B5 Department of Primary Industries

This chapter addresses issues raised by the NSW Department of Primary Industries (DPI).

Figure 6-19 Forward tracking from tidal areas showing particle travel time in years

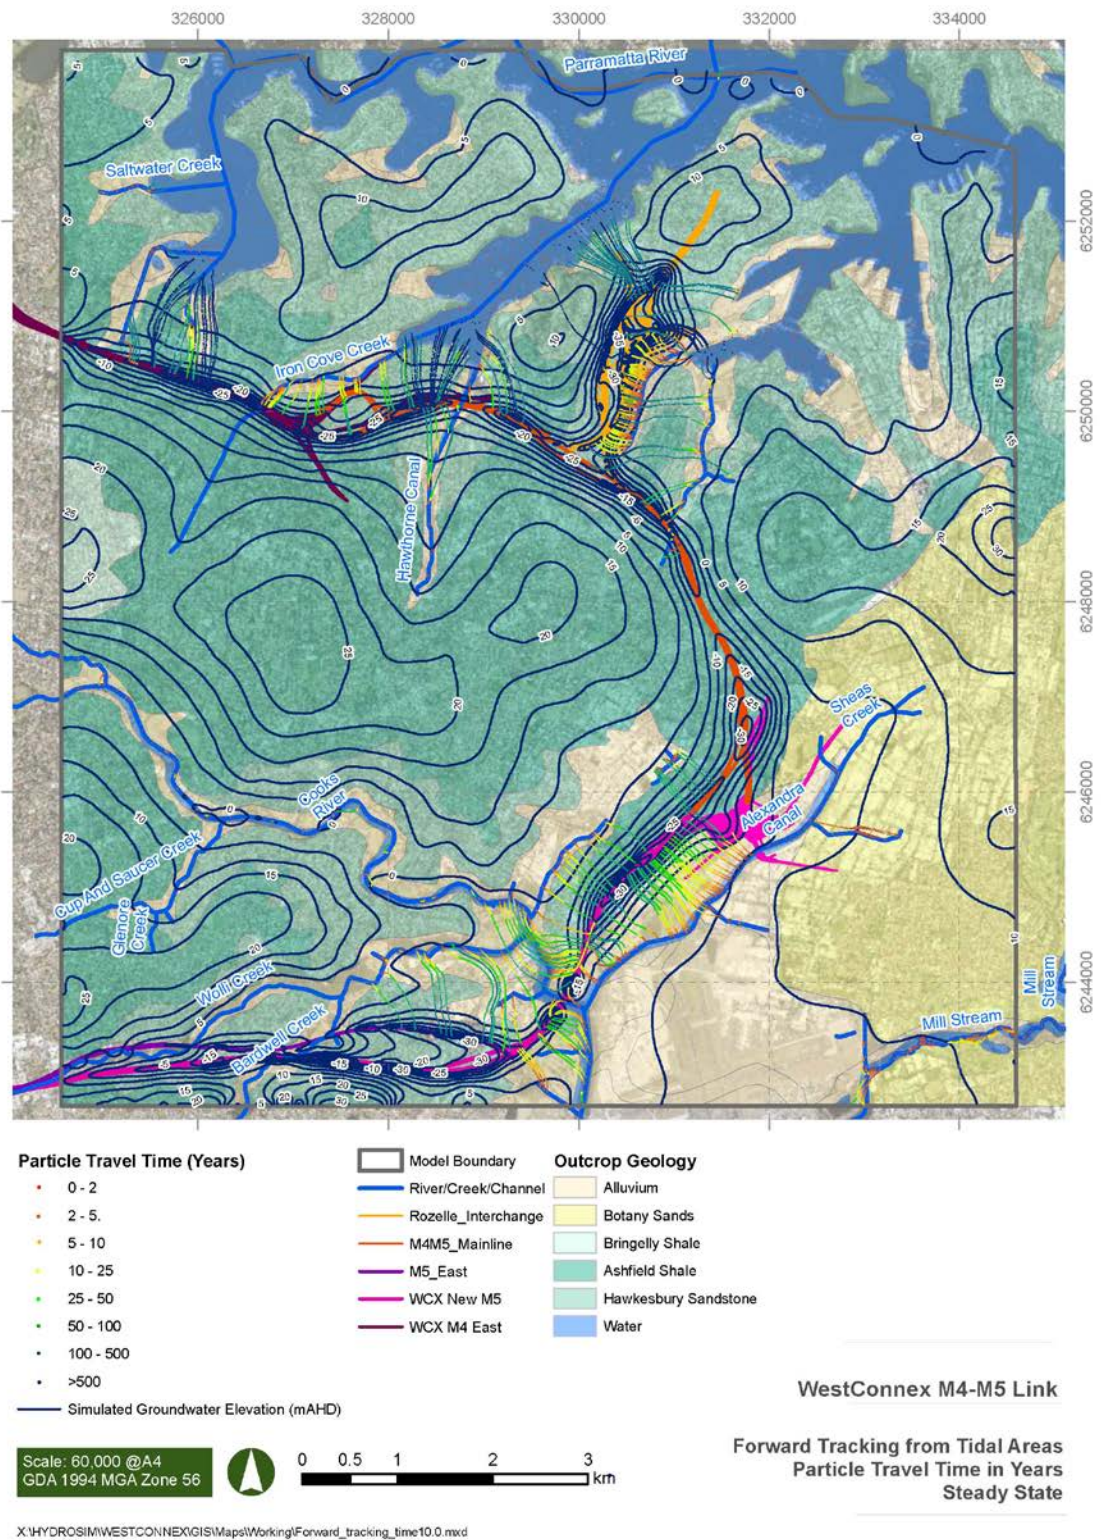
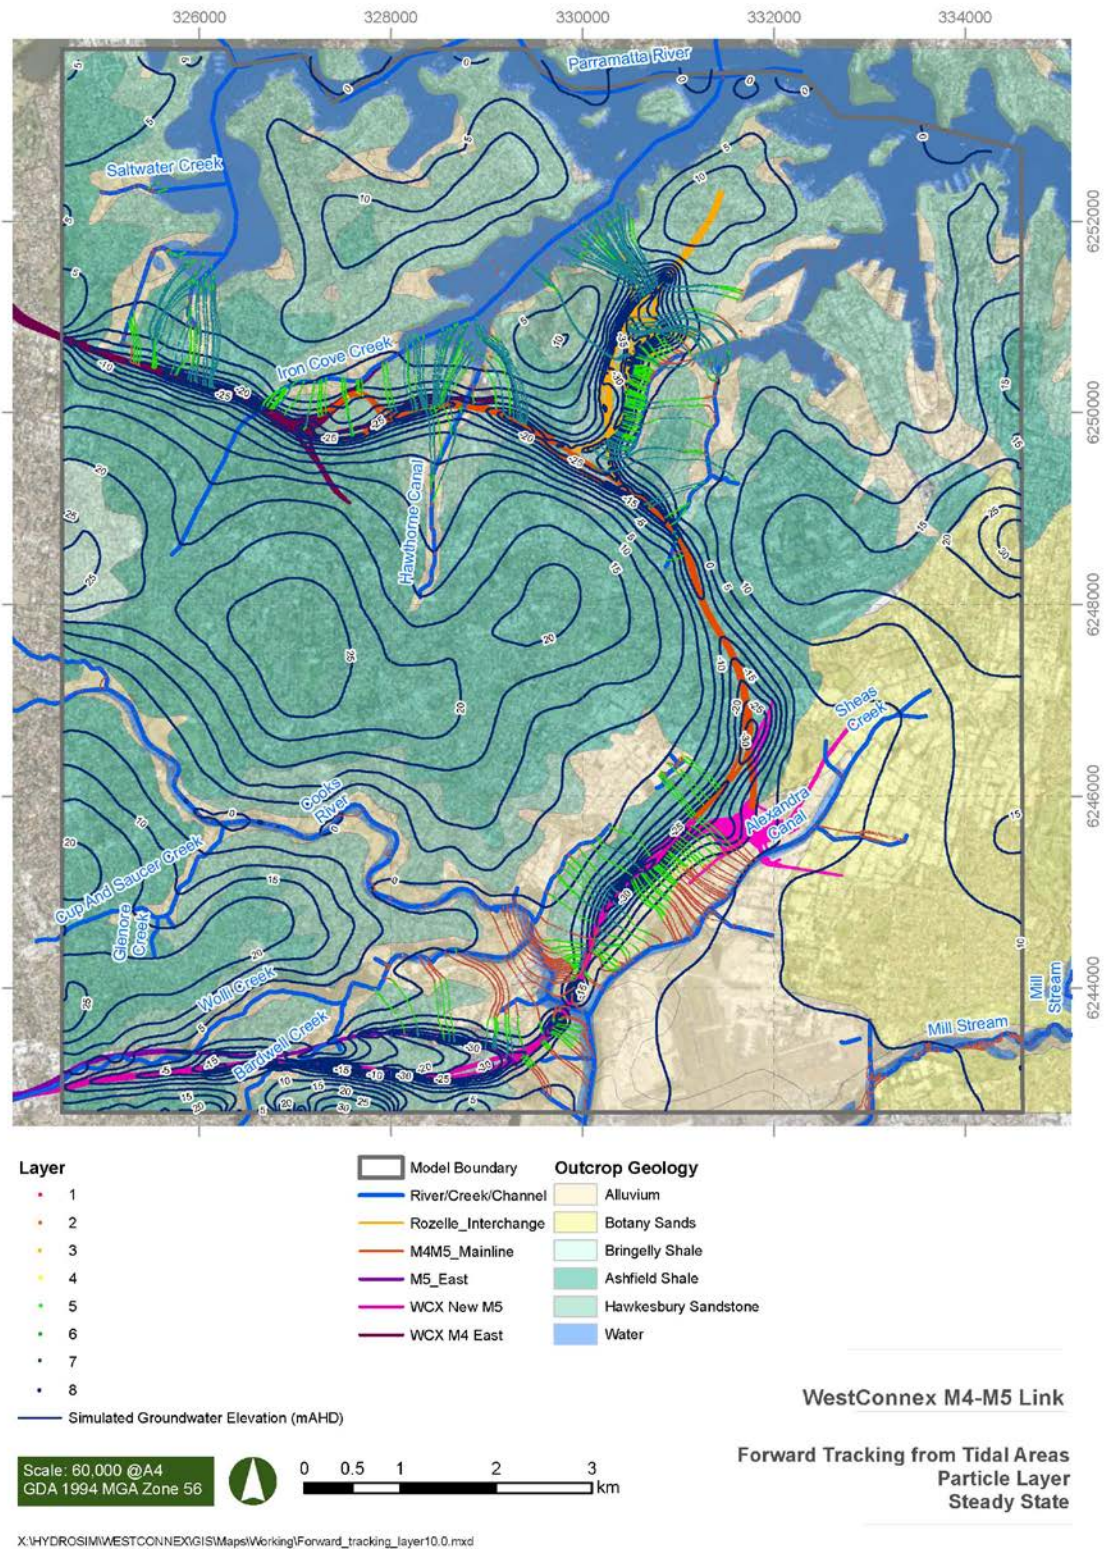
DPI considers that the largely untanked (unlined) sections of tunnel which require continuous dewatering will exceed the Level 1 water quality criteria under the Aquifer Interference Policy and will trigger Level 2. The proponent should demonstrate where salt water intrusion from tidal areas will occur and then re-analyse these impacts on sensitive uses of the groundwater. The proponent should also confirm if the particle tracking component of the groundwater model was sufficient to analyse these overall impacts of salt water ingress to the tunnel ecosystems along this tidal fringe.

Four key areas have been identified that may be subject to saltwater intrusion as shown on **Figure B5-4** and **Figure B5-5** (refer to Figure 3-2 and Figure 2-3 of Appendix T (Technical working paper: Groundwater) of the EIS). These figures show the direction of flow of saline surface water towards the tunnels and the initial area of influence. These identified areas are:

- Lilyfield and Rozelle on the south eastern edge of Iron Cove
- Rozelle west of White Bay
- Rozelle west of Rozelle Bay
- St Peters north-west of Alexandria Canal.

Following construction, it is recommended that existing monitoring wells between these foreshore areas and the project tunnels are identified and are added to the groundwater monitoring network to monitor for any changes in groundwater quality that could be attributed to saltwater intrusion.
